Recommendation Report for Planning Permission for Works or Extension to a Dwelling

REF NO: Y/7/21/HH

LOCATION: 14 East Bank
North End Road
Yapton
BN18 0DJ

PROPOSAL: New vehicular access.

Proposed Plan - 1:100 @A1

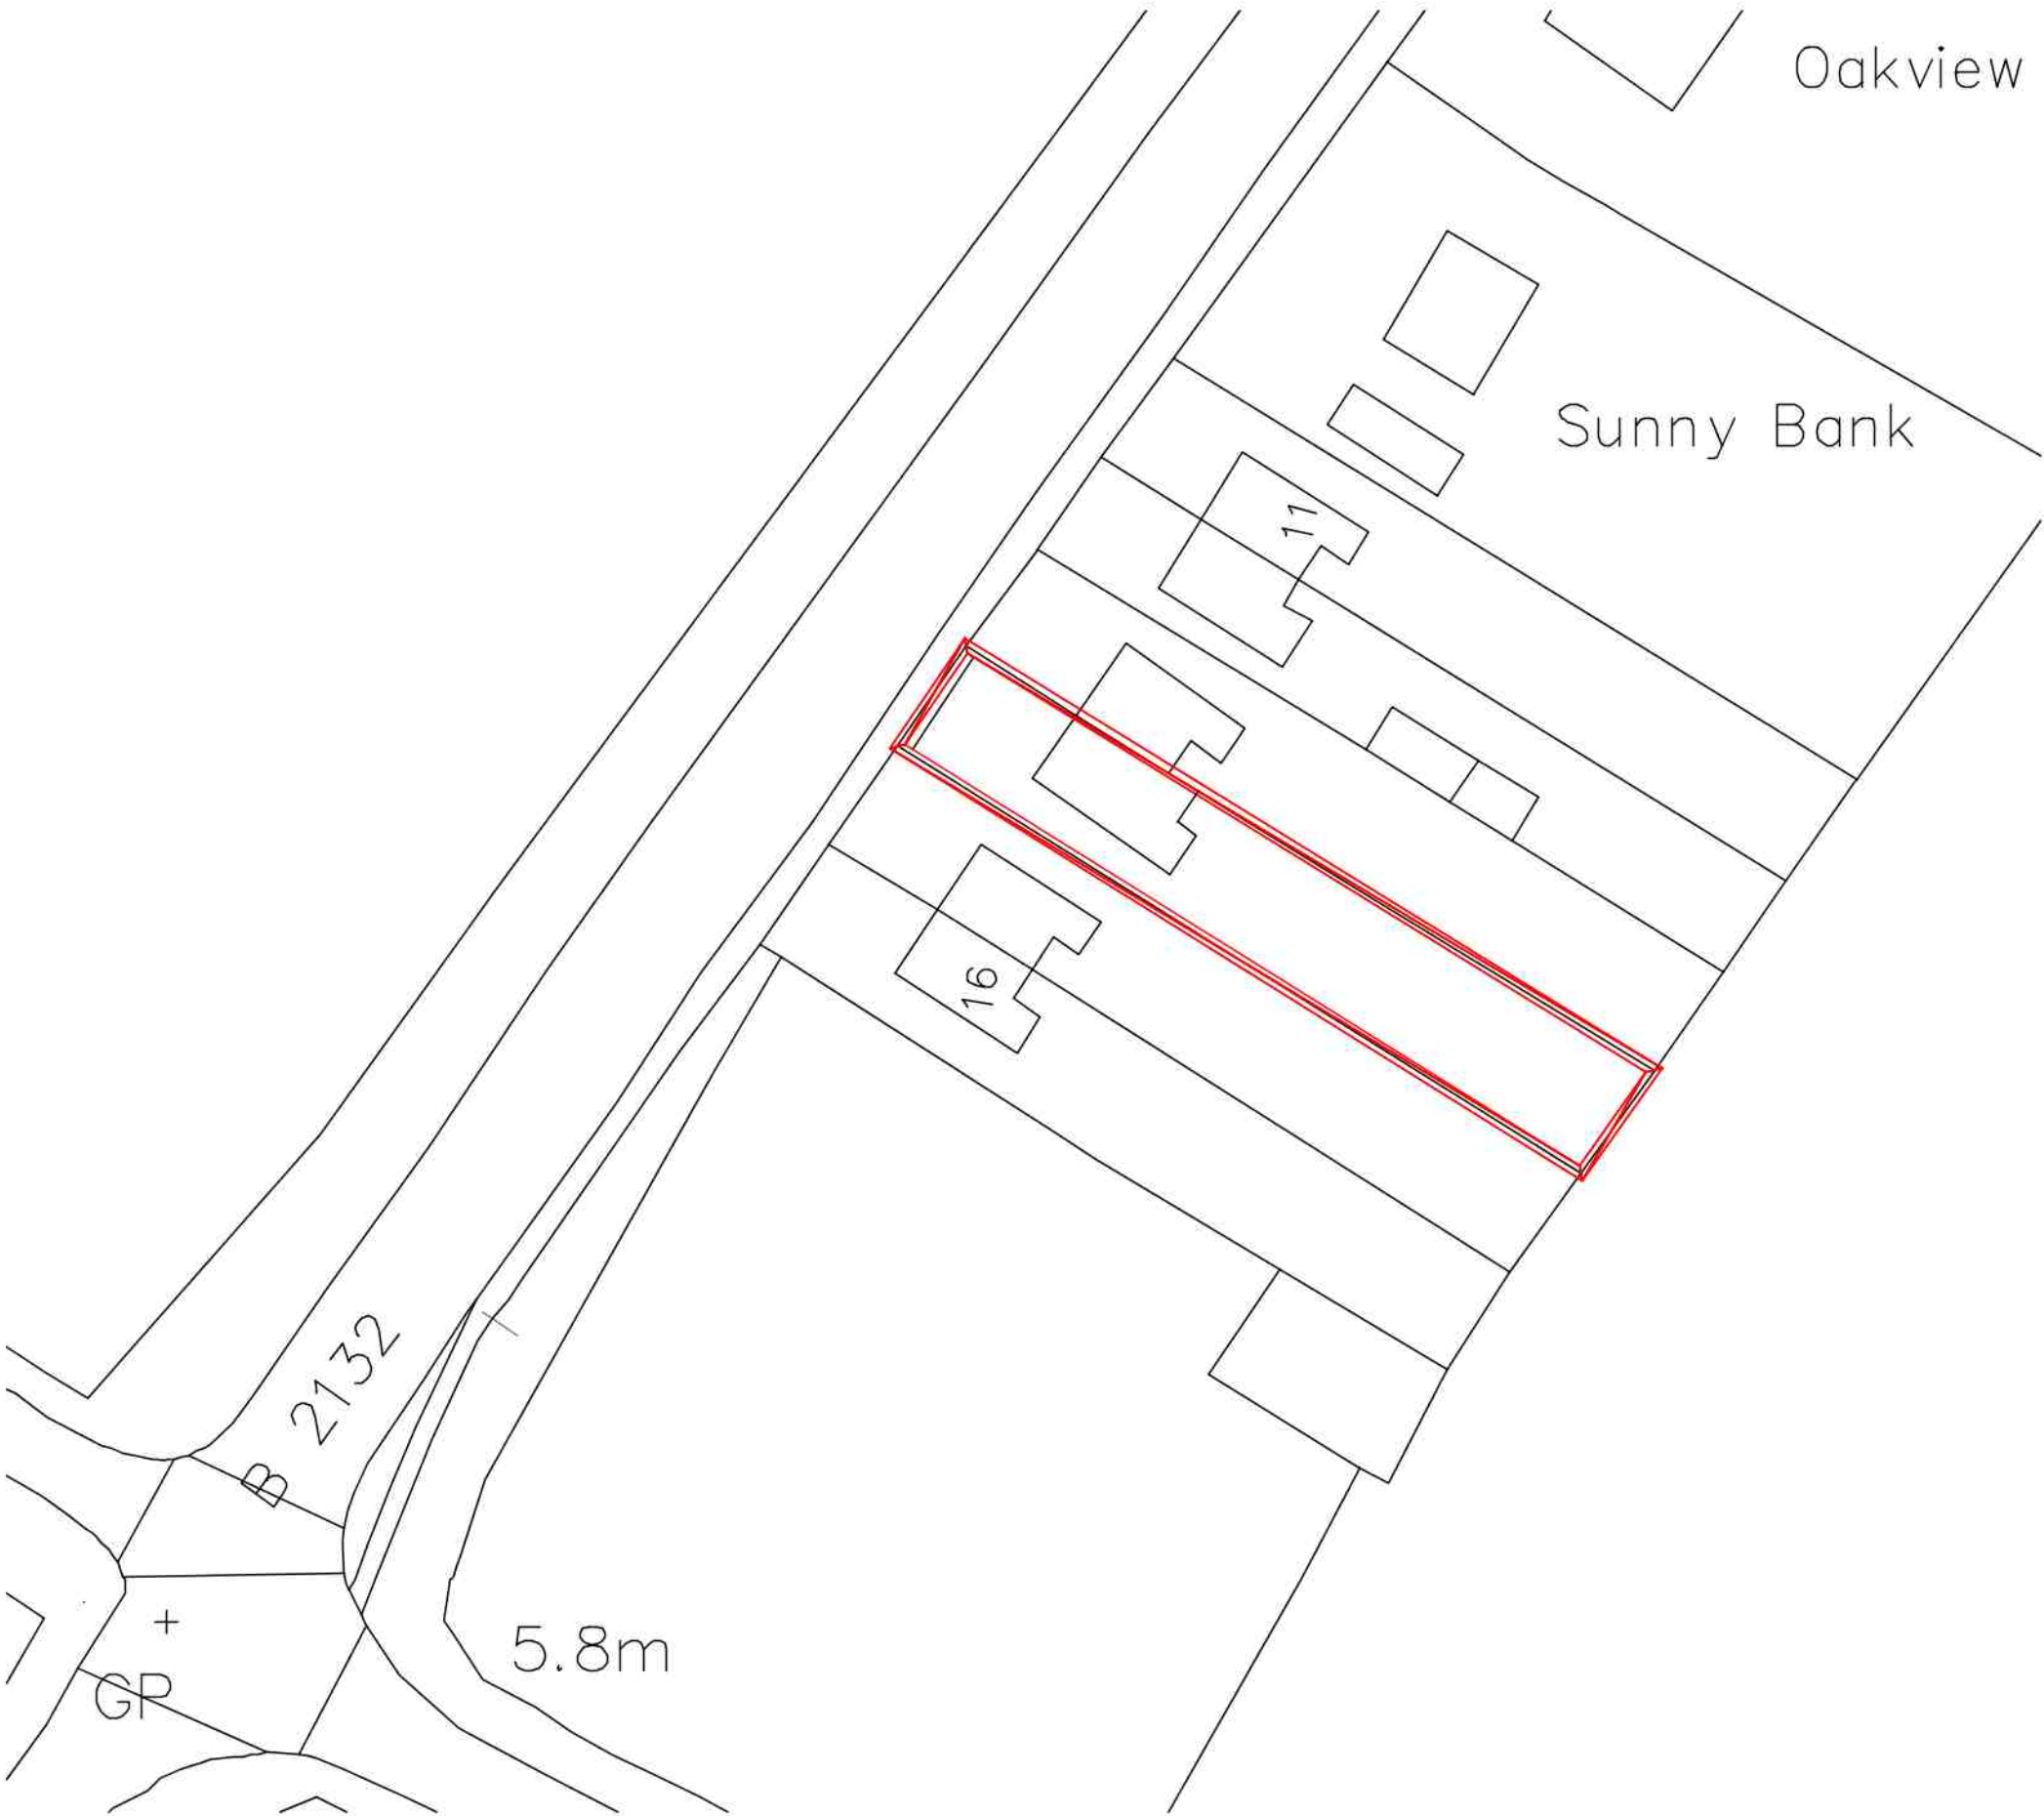
WSCC Highways - VCO's are normally wider at the kerbside and taper back towards the drive. Details of this can be secured via condition. MfS guidance states that, Vehicle exits at the back edge of the footway mean that emerging drivers will have to take account of people on the footway. The absence of wide visibility splays at minor accesses will encourage drivers to appear more cautiously. Following this guidance, the LHA raises no concerns over the lack of the details. The LHA appreciate that the proposal could see the removal of up to 3 cars from the highway, in an area that currently has on street parking pressures. The LHA does not consider that this proposal would have an unacceptable impact on highway safety.

It is not considered the condition is necessary, WSCC raise no concerns over the absence of the wide visibility splays.
